S19-0011_LHAP SSD10389 LETTER MW CLOUSTON_Rev 1_CL
21.8.2020

LIVERPOOL HOSPITAL INTEGRATED SERVICES BUILDING (SSD 10389) - RESPONSE TO AGENCY SUBMISSIONS

CLOUSTON Associates are the Landscape Architects for the LHAP (SSD 10389) project. The following responses address key landscape-related comments received from Liverpool City Council.

CAMPBELL STREET

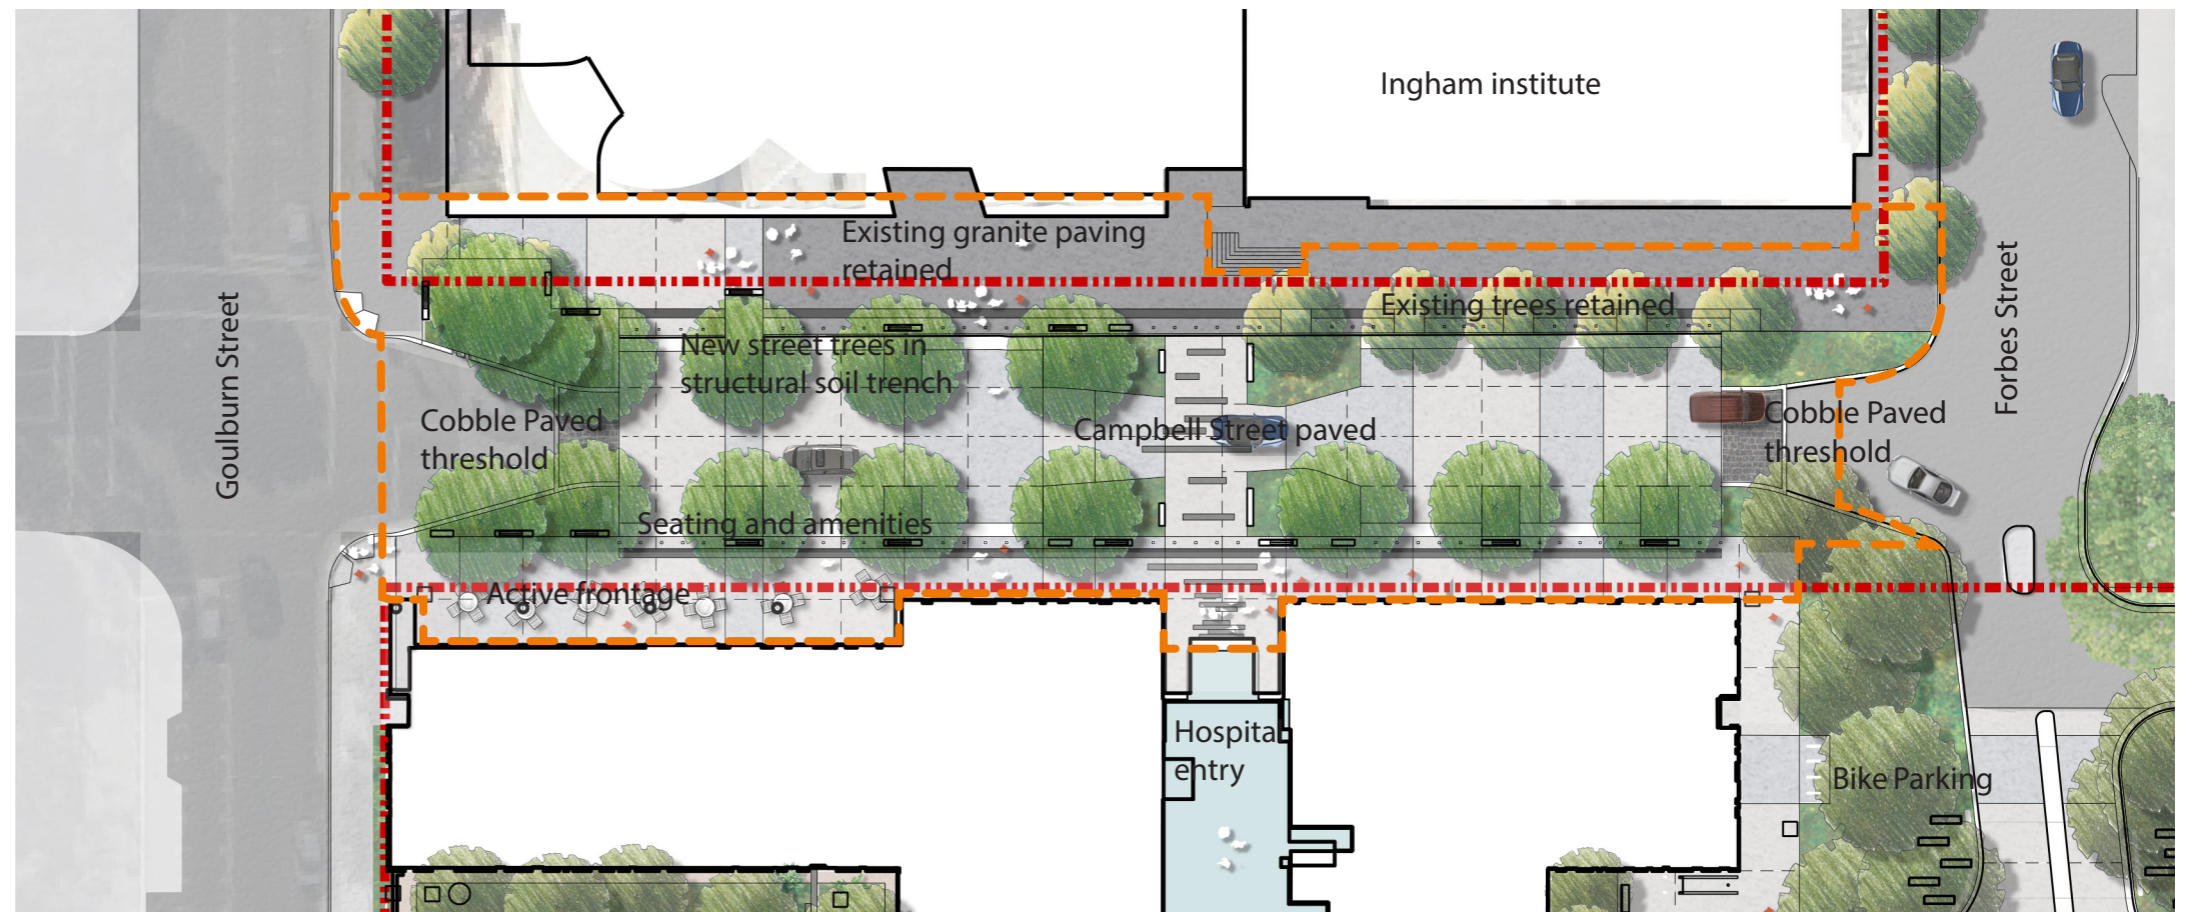
*All new tree planting must be installed as minimum 100L potted stock. Council requests the retention of the *Corymbia citriodora*, Lemon Scented Gums on Campbell Street. These are significant trees with large canopies and must be retained.*

CLOUSTON Response: CLOUSTON confirms that all new tree plantings will be minimum 100 litre stock. The retention of the *Corymbia citriodora* has been raised with LCC previously. Retention is not possible due to crown impacts with adjoining buildings. These trees will be replaced with *Lophostemon confertus*, which can be managed to avoid the recurrence of such impacts, while providing additional benefits to heat island impacts from a denser canopy.

While the loss of visual amenity of these trees is acknowledged, it is worth noting that findings in the Liverpool City Council's pilot study on heat mitigation (described in the LCC PDMP), demonstrates that the more open canopy tree species, typically seen in *Corymbia citriodora*, has less impact on heat mitigation than the denser canopy of native species such as *Lophostemon confertus*.

Figure 1 Proposed Goulburn Street entry forecourt

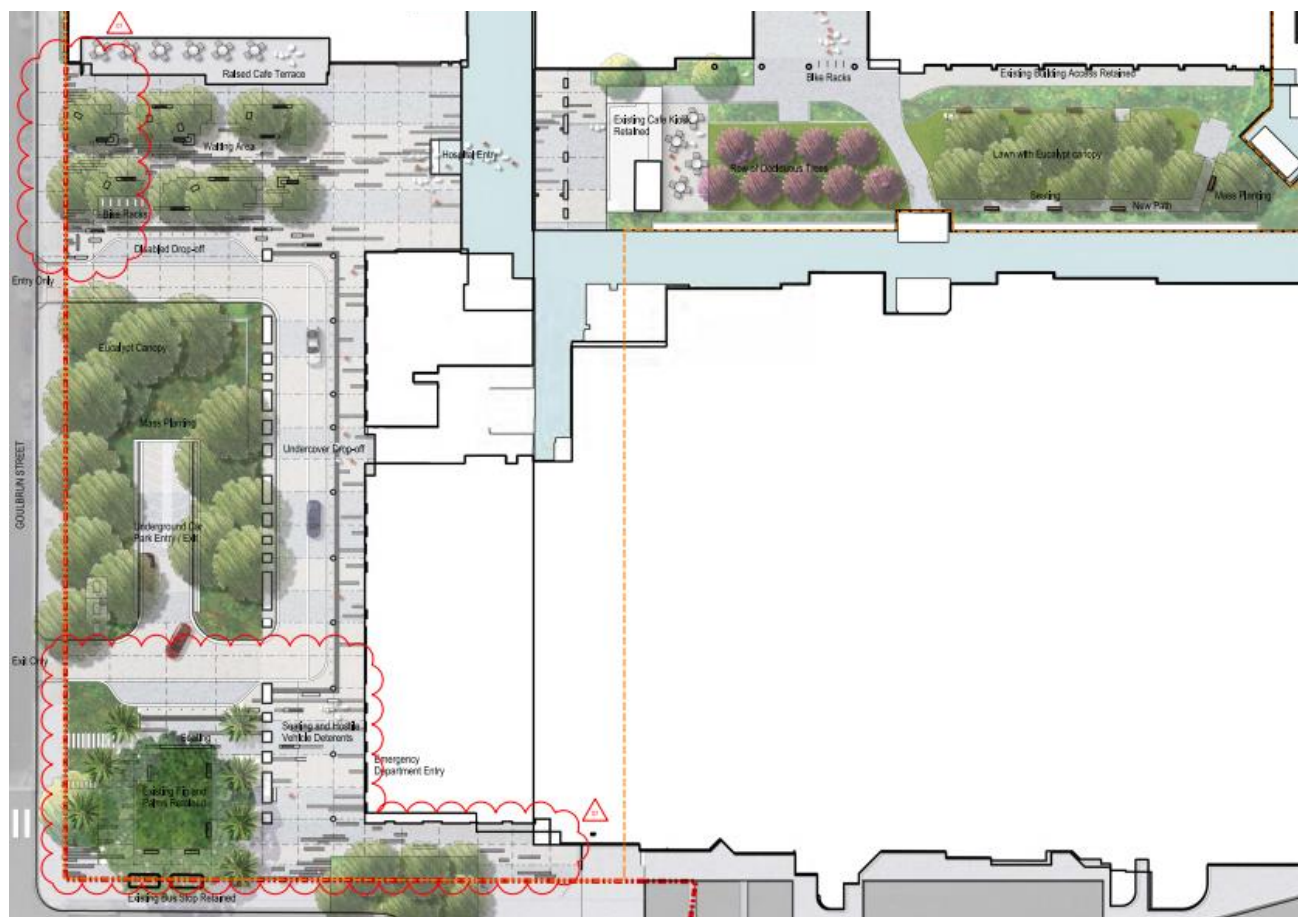
The pavement design for any public domain works need to be in accordance with the paving strategy outlined in the draft LCC PDMP. See Chapter 6.13 'Paving' for core street paving typology (i.e. for treatments along Goulburn Street and Elizabeth Street). Paving treatments need to extend from the kerb to the building line on the ground floor, to create a seamless public/private domain (i.e. also consistent with Council's DCP). If any other paving design (e.g. feature paving) is being proposed within the lot boundary, the proposed paving within the private domain needs to integrate with the paving design in the public domain, as per the draft LCC PDMP.

With respect to integrating paving from the streetfront into the hospital forecourt, taking material inspiration from the surrounding granite street paving, directional bands of dark granite are proposed for the paving on the forecourt area of the hospital. Starting at the property boundary along Goulburn Street bands of granite within exposed aggregate concrete seamlessly transition from the all-granite streetfront paving.

The directional nature of the banding draws visitors through the lushly planted forecourt into the Main Entry of the Hospital. This granite banding is repeated across the site as an additional layer to the wayfinding strategy to subtly differentiate main building entries and provide a simple unifying ground plane footprint.
